Reference No: 2020/62/92004/W

Site Address: 3, Reinwood Avenue, Quarmby, Huddersfield, HD3 4DP

Description: Erection of two storey side and single storey rear extensions

DECISION – CONDITIONAL FULL PERMISSION

Drawing Number_
19_805 101

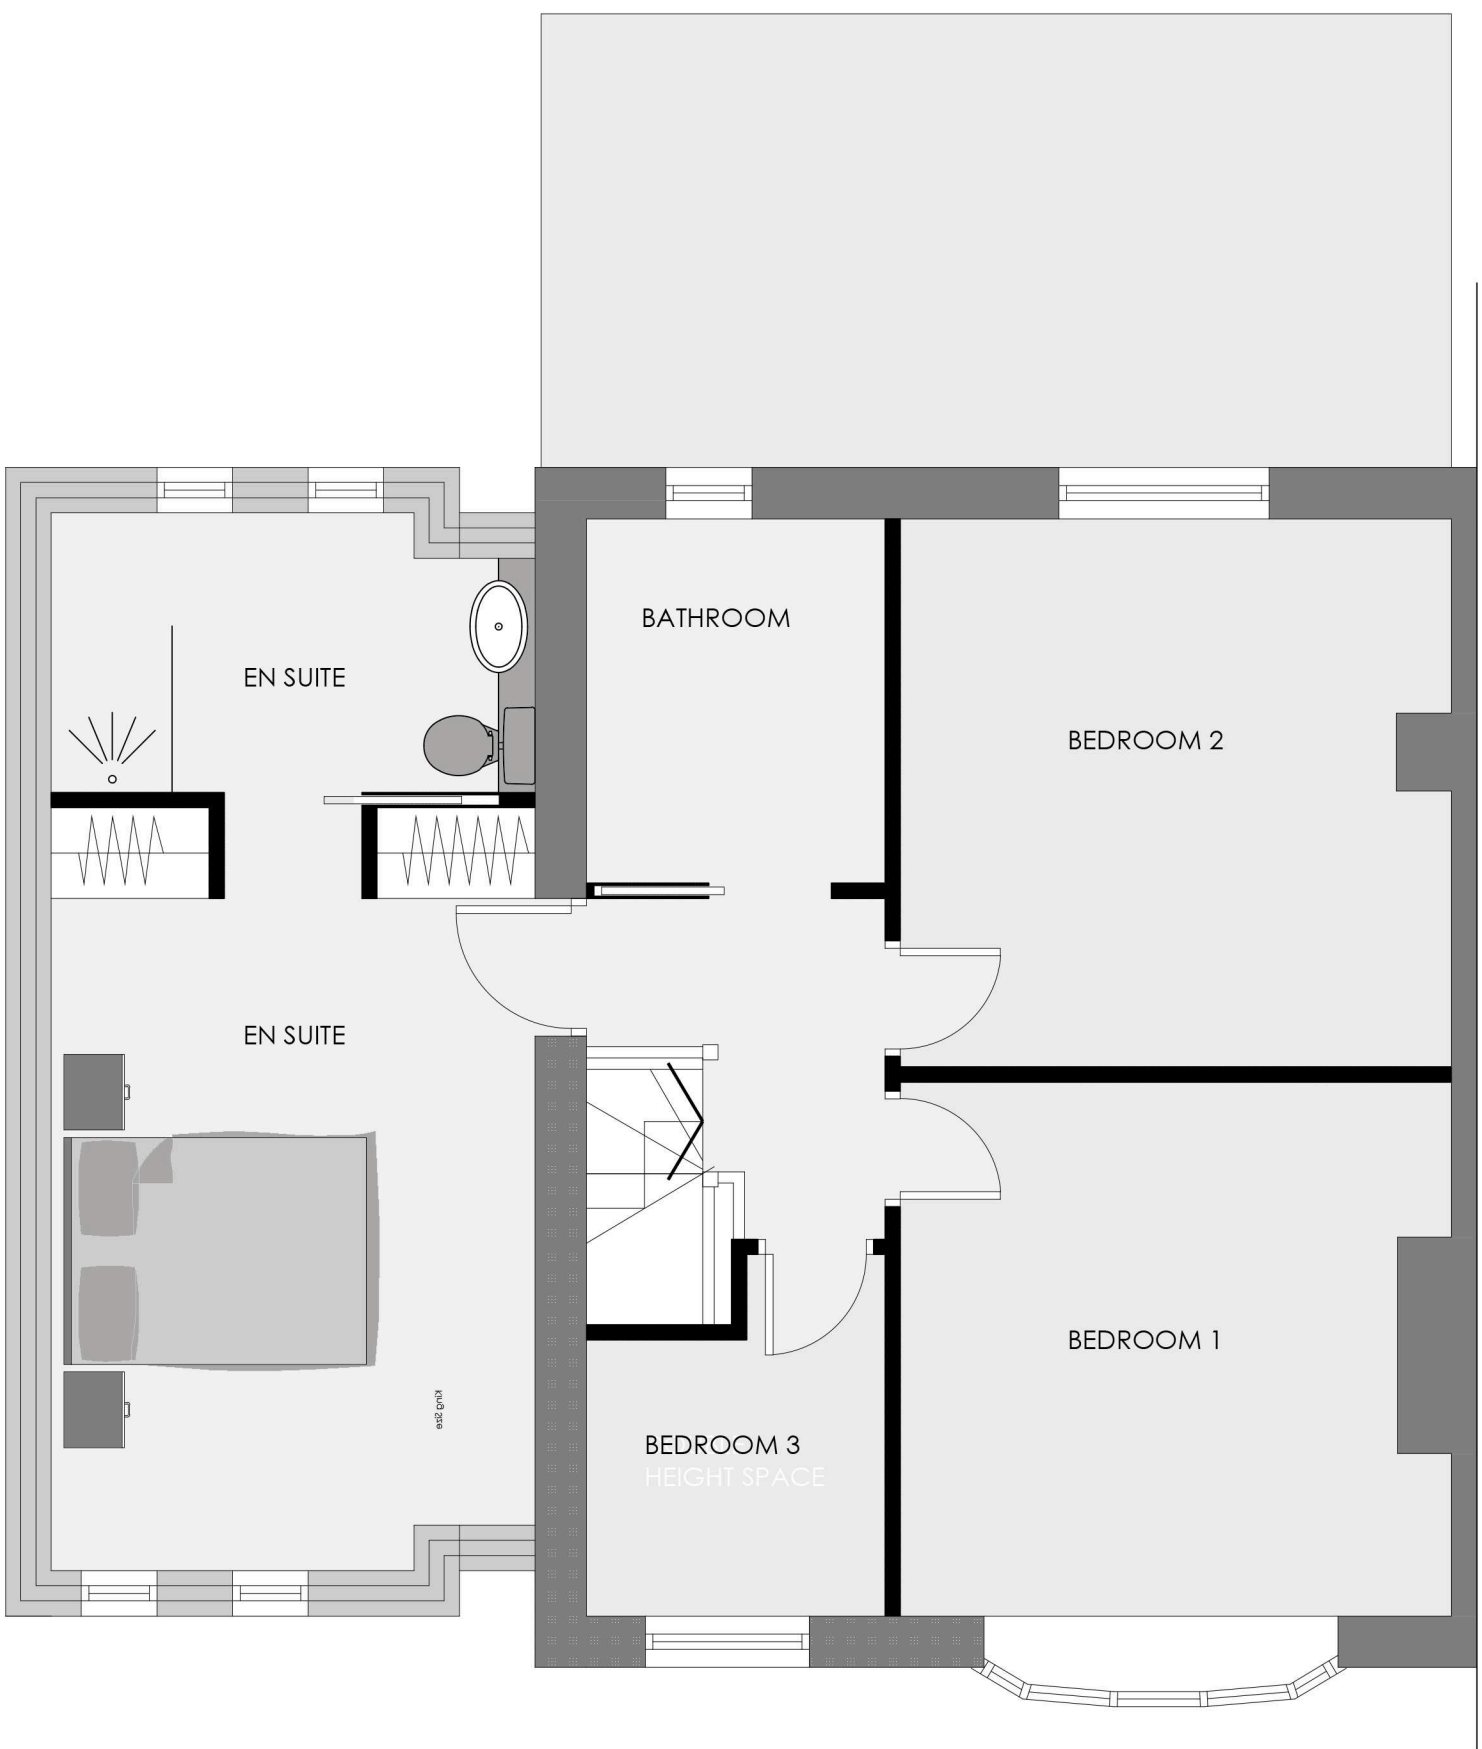
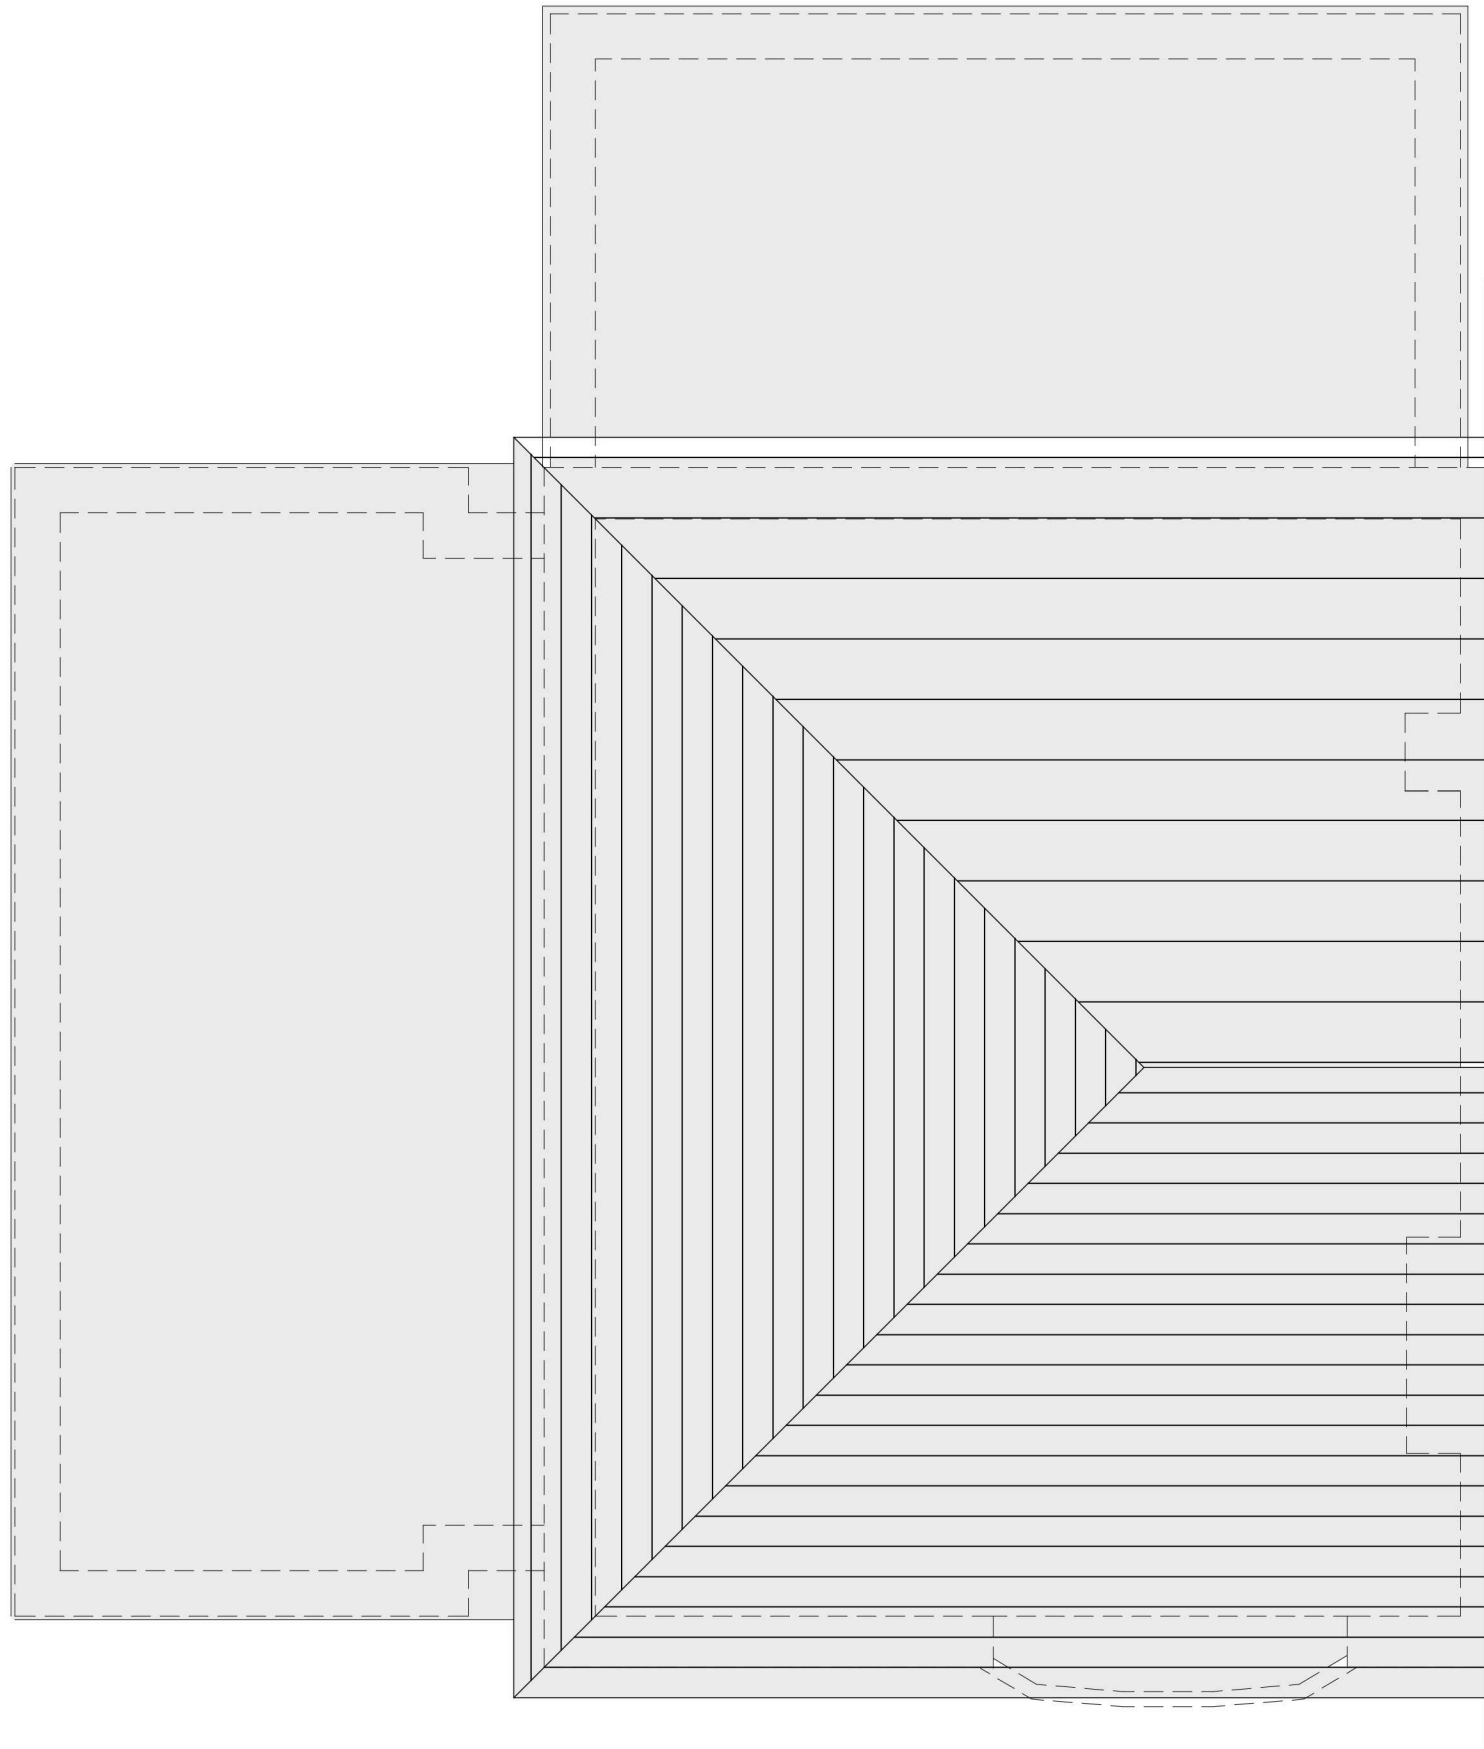
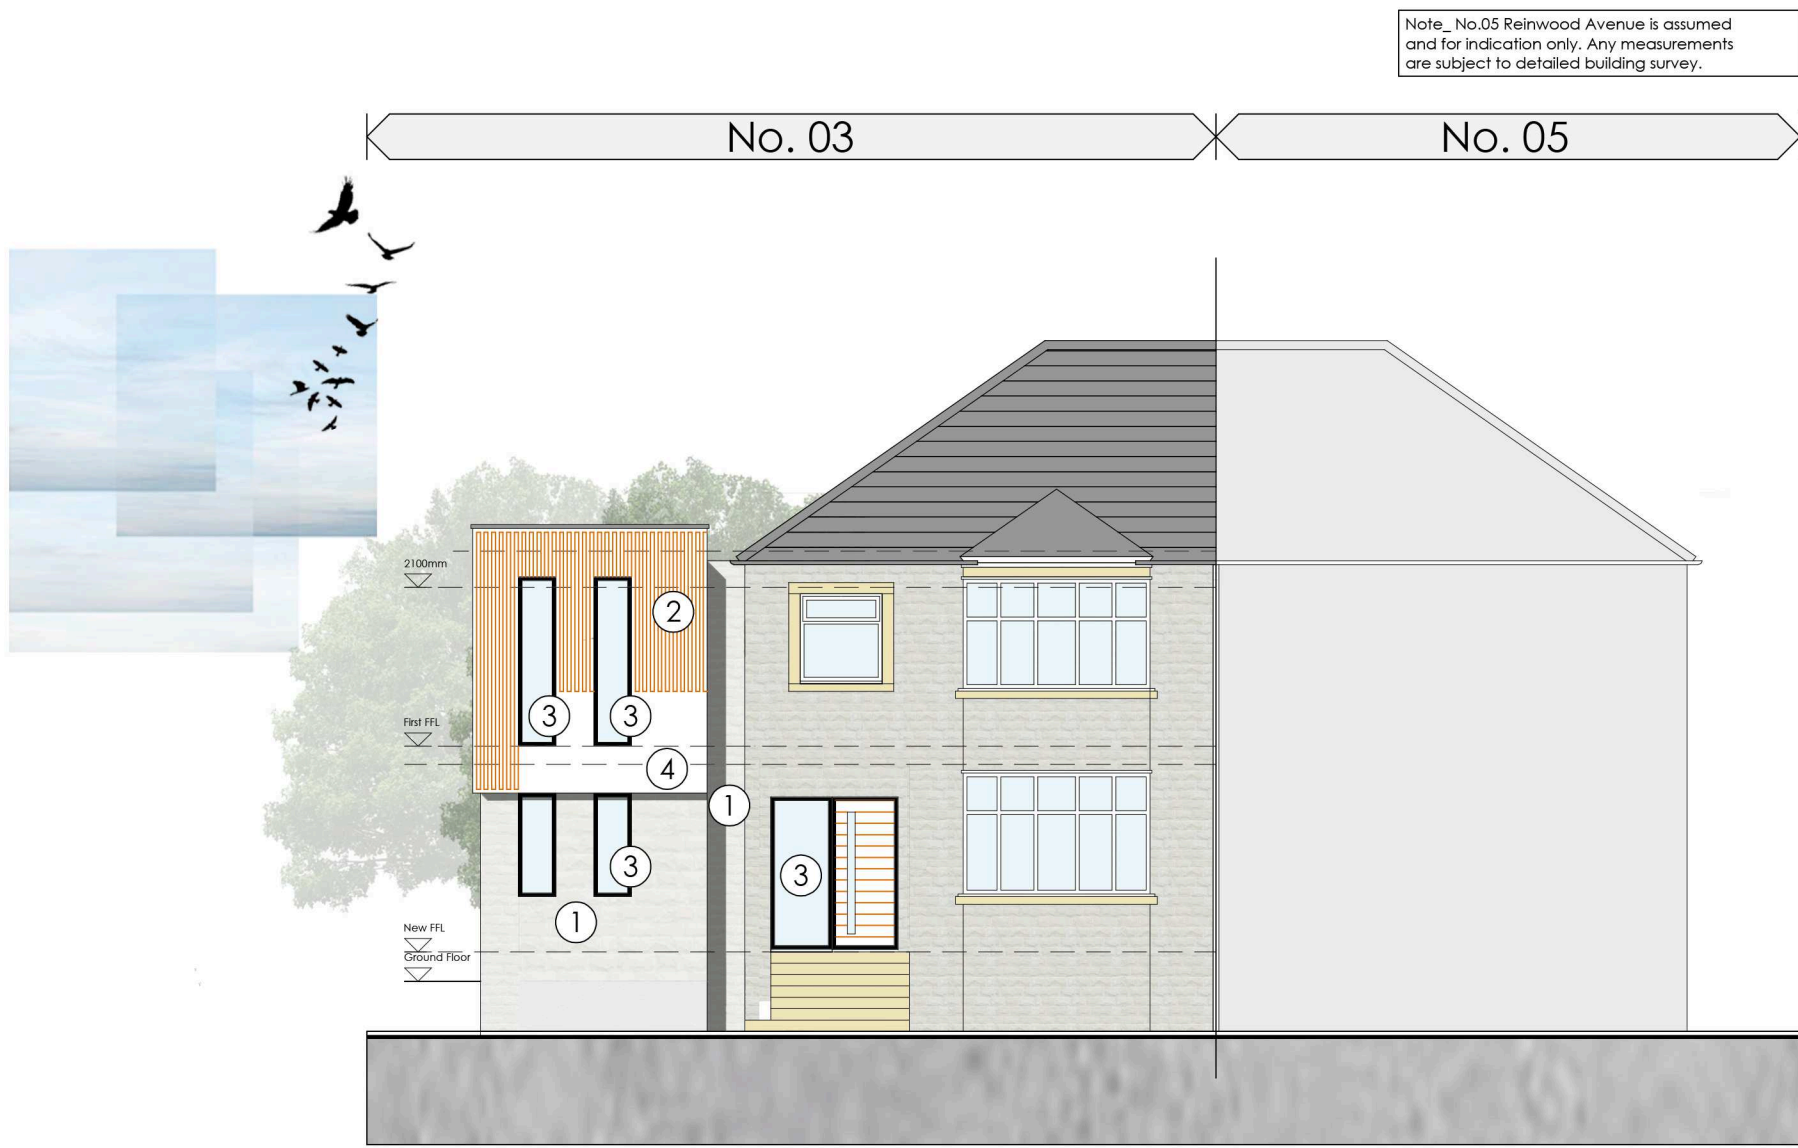
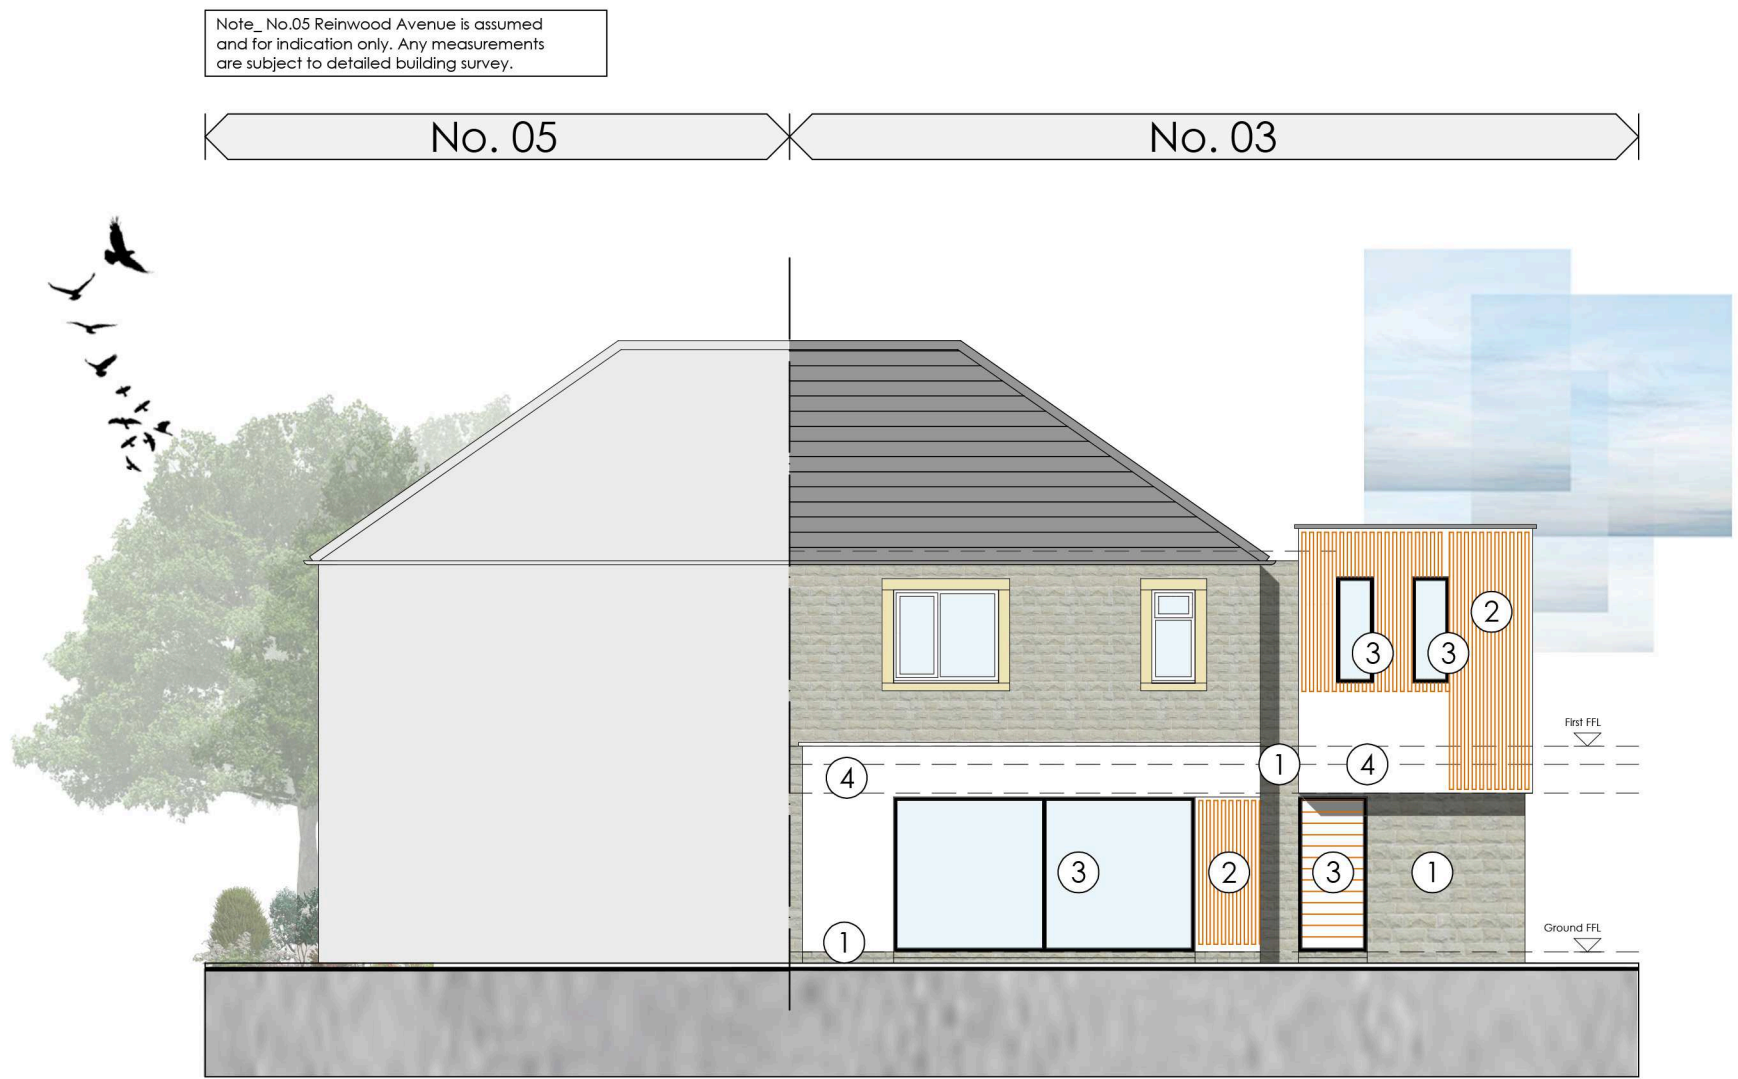
Concerns were raised with the initial submitted proposal due to the proposed flat roofed two storey extension and the proposed construction materials. In response, the plans have been amended with the alterations summarised as follows:

- Traditional roof form added
- Removed timber elevations at first floor and replaced with white render
- Window details amended to be more in keeping with the existing

- Retained stone at ground floor
- Extended the rear elevation across the rear of the two storey extension

The design of the proposal has been amended from a two storey flat roof timber clad structure to a more traditional structure which would be rendered to the first floor with a white coloured finish. Whilst this would introduce a new finishing material to the property, the neighbouring property has a rendered first floor and there are properties within the street scene that are finished with a white coloured render and therefore the use of such a material is considered acceptable. The use of timber cladding has been significantly reduced. Furthermore the roof has been redesigned to be in keeping with the hipped roof design of the existing dwelling.

The window openings have also been amended and are more in keeping with the host dwelling and therefore also considered to be acceptable.
